**Response to Submissions
Mosman High School Upgrade
SSD 10465**

This document is provided by Woods Bagot, the architects for the project, as a response to the relevant submissions provided by DPIE, for the Mosman High School Upgrade State Significant Development Application.

1 Winter Solstice - 1pm Existing

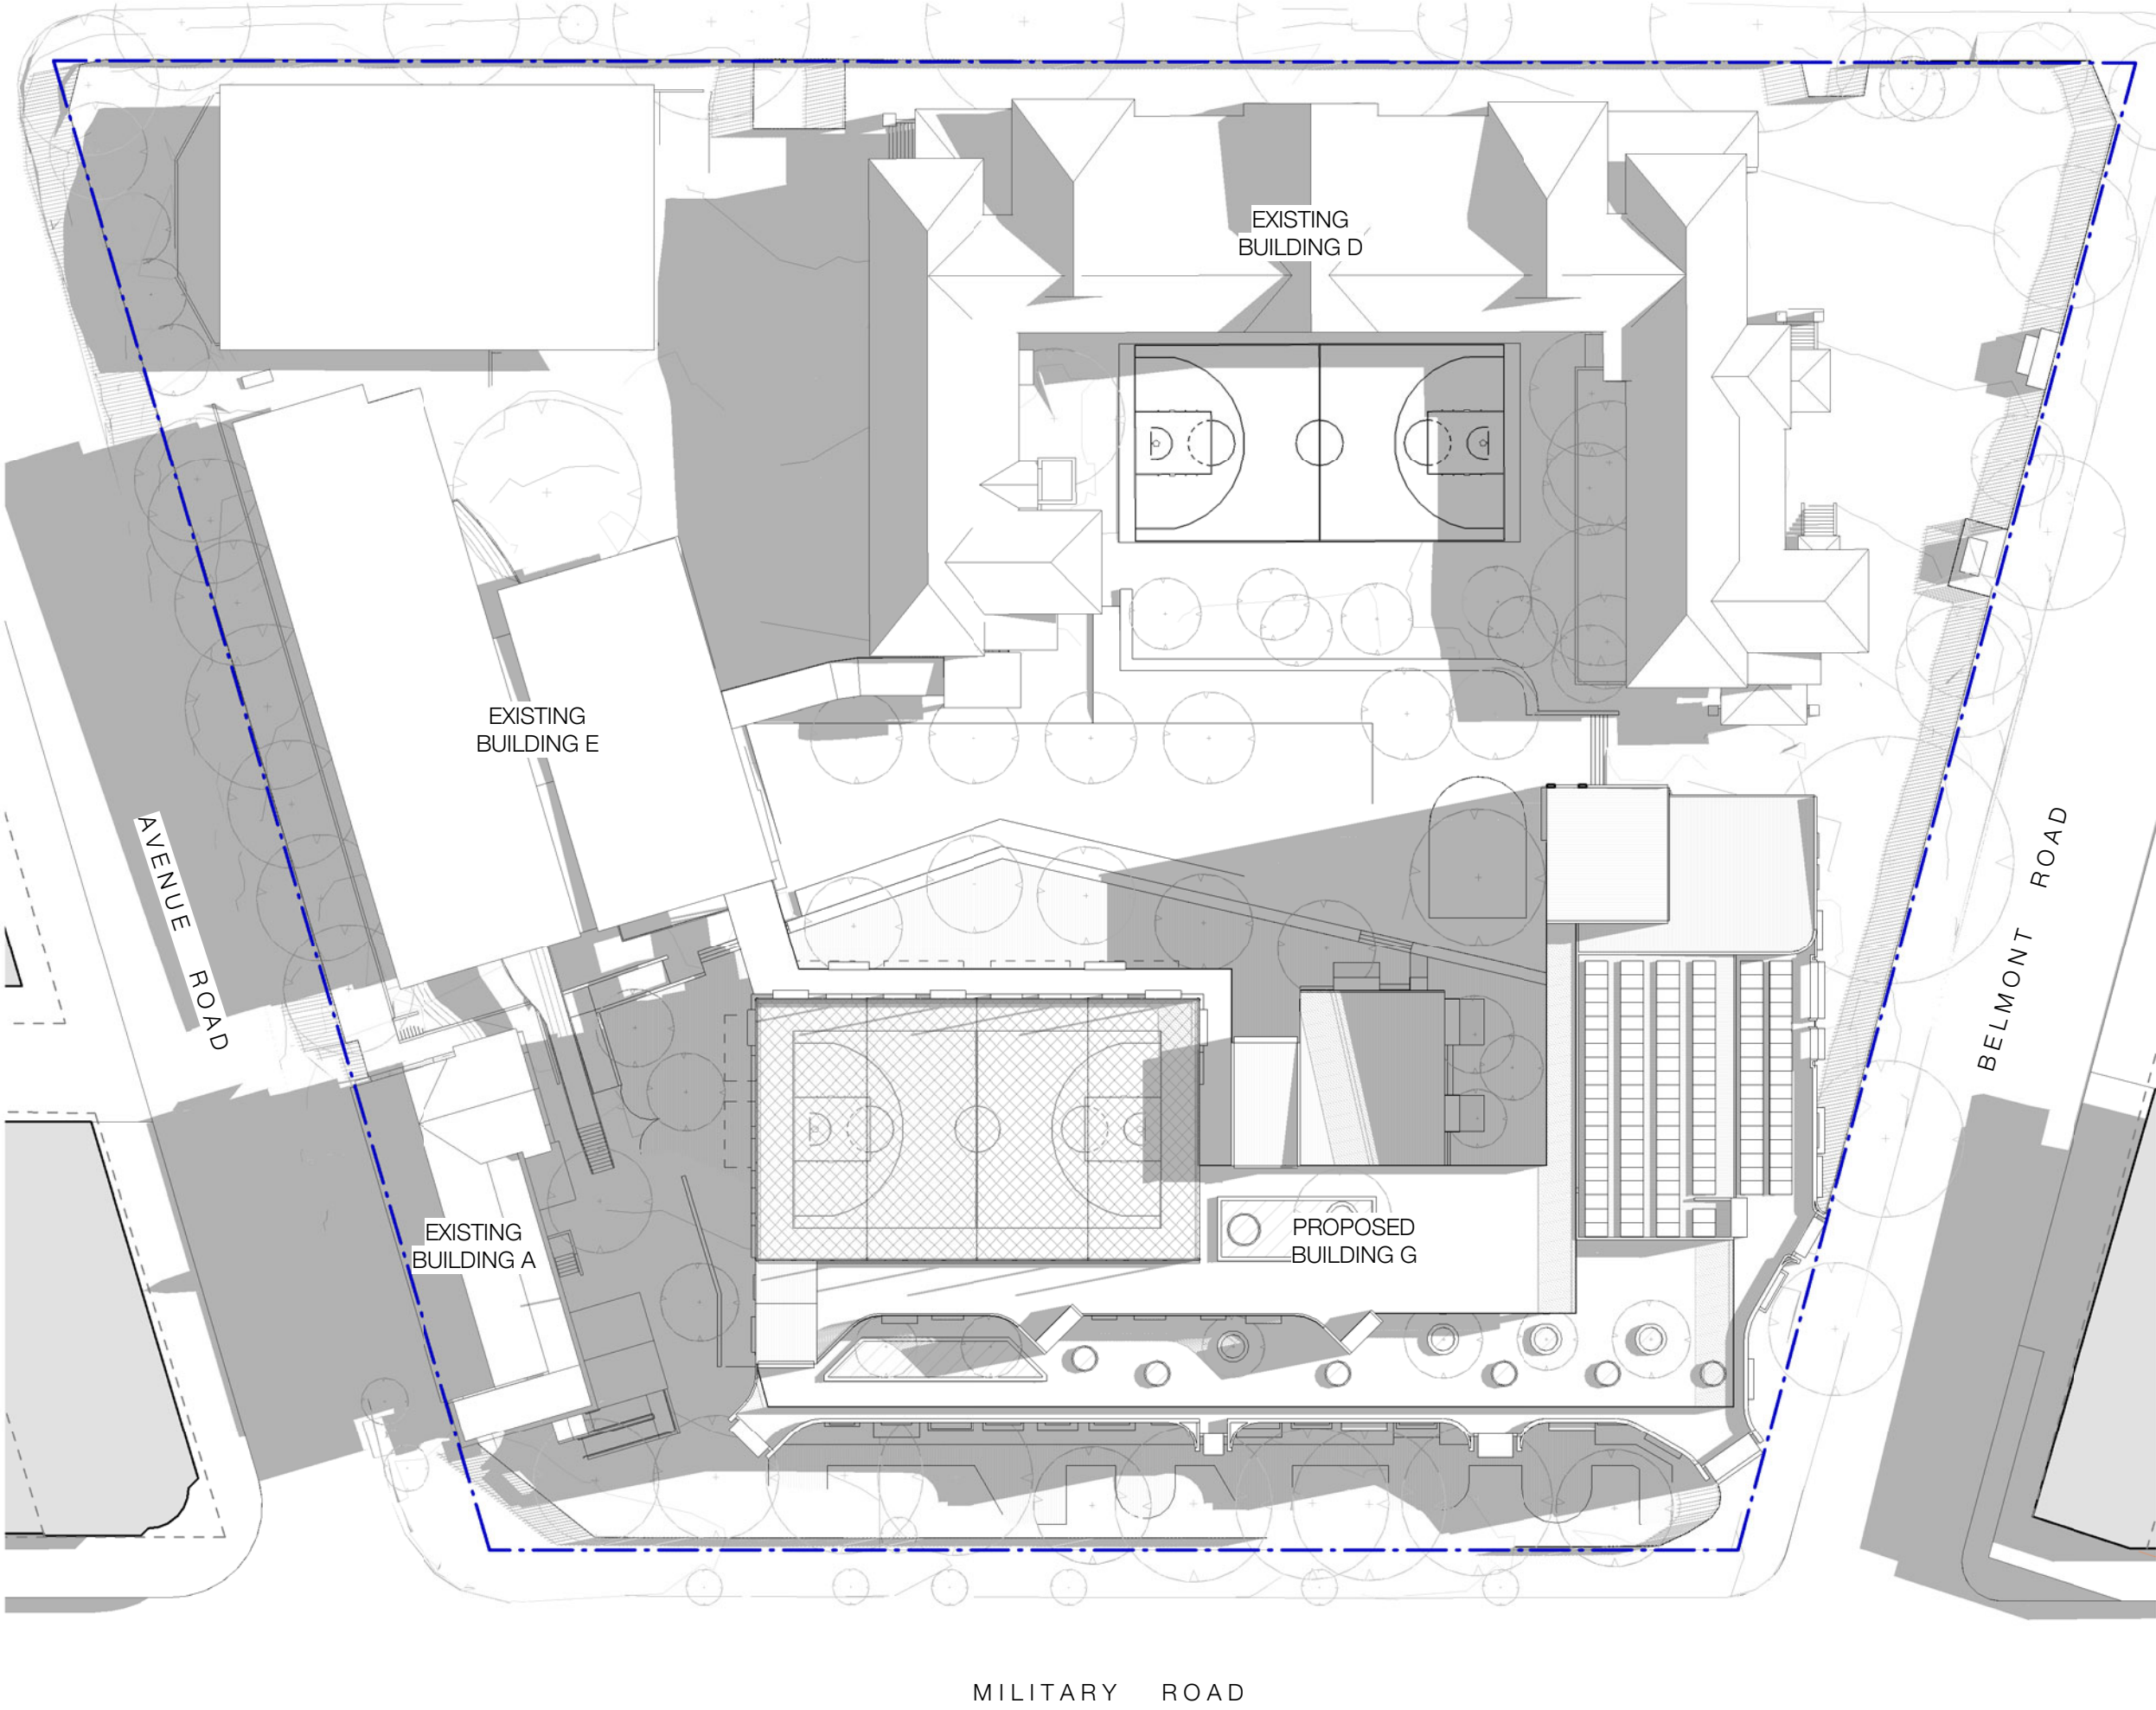
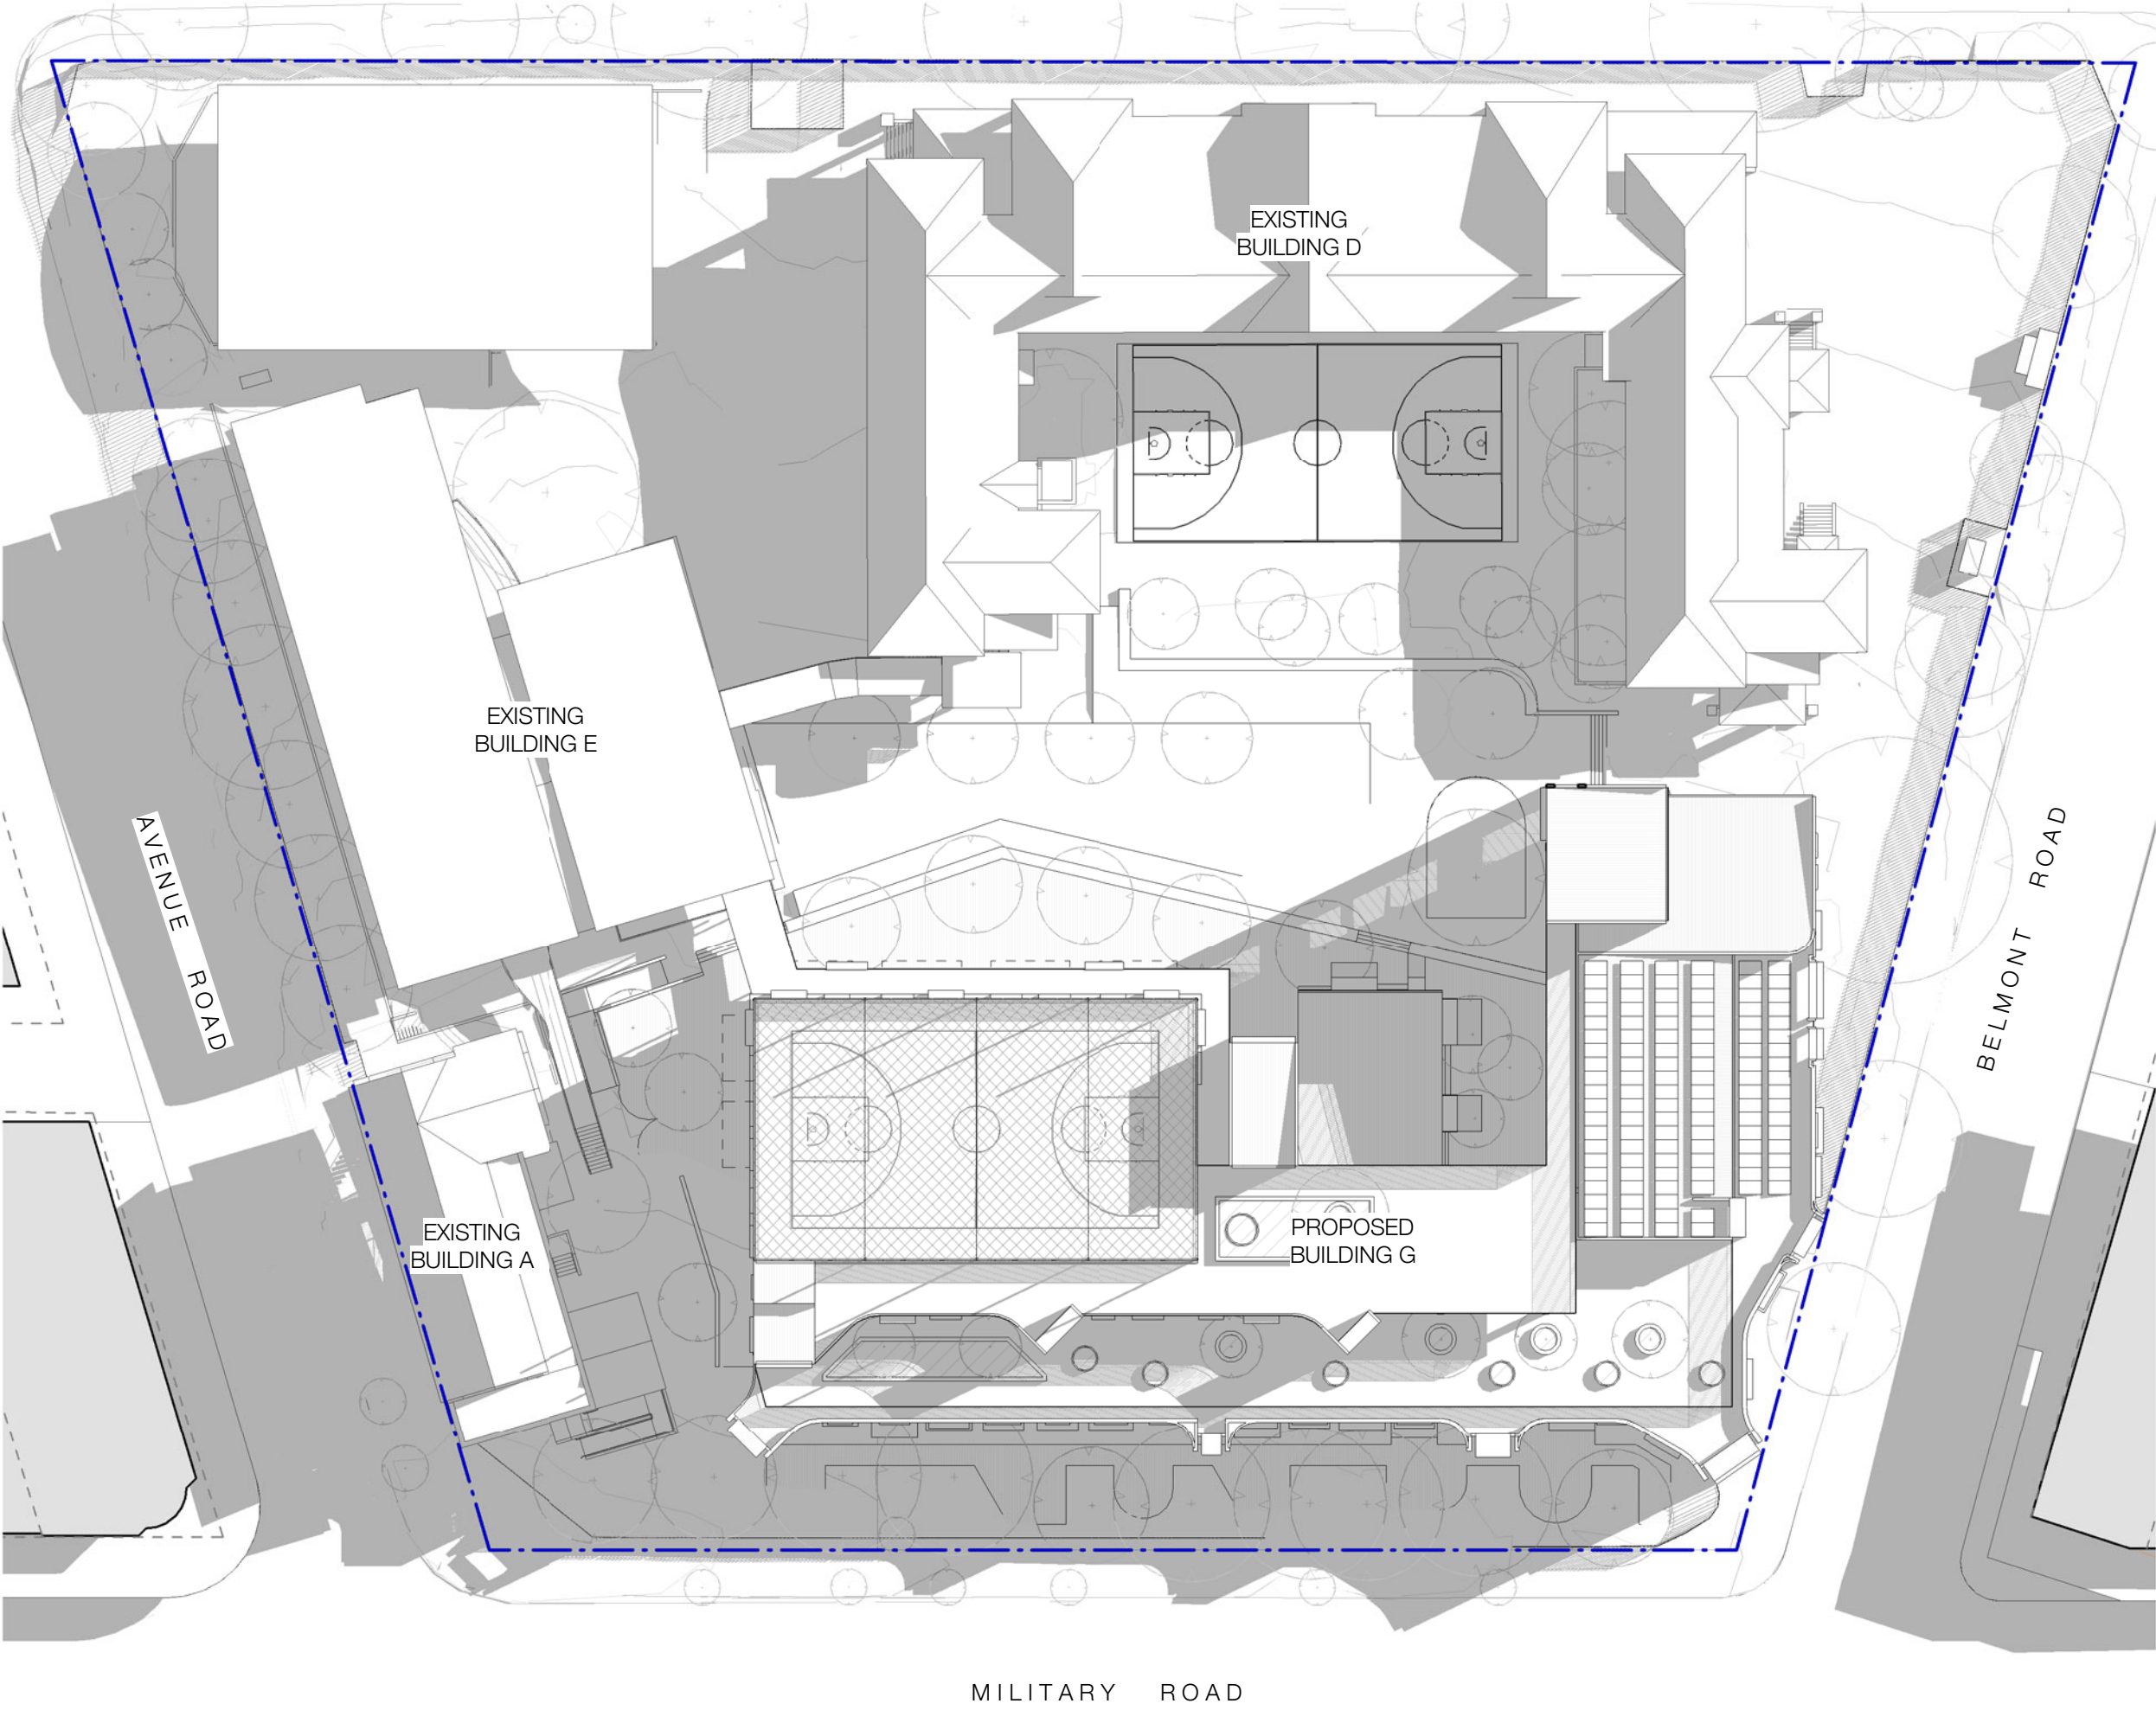
We note that plans submitted for public comment are only PRELIMINARY. This is unacceptable as they are technically incomplete and do not reflect the actual site complete shadow diagrams. Evidenced by the missing presentation of FULL SHADOW DIAGRAMS on impacted (Morning) Belmont Road, Keston Avenue & Avenue Road e.g. South West corner 6:00am(Summer) to 7:30am(Winter). Let's be honest – Easterly morning sun shine is critical to our neighbours amenity. (Afternoon) – Military Road retail shopping strip (Winter) 3:00 - 5:00pm. Let's keep the retail street sunny and a great place to shop.

Shadow diagrams are enlarged to capture the extend of Belmont Road, Avenue Road and Gladstone Avenue. There are no further shadowing impacts to Keston Avenue from Proposed building G from 9am to 3pm, winter and summer solstice.
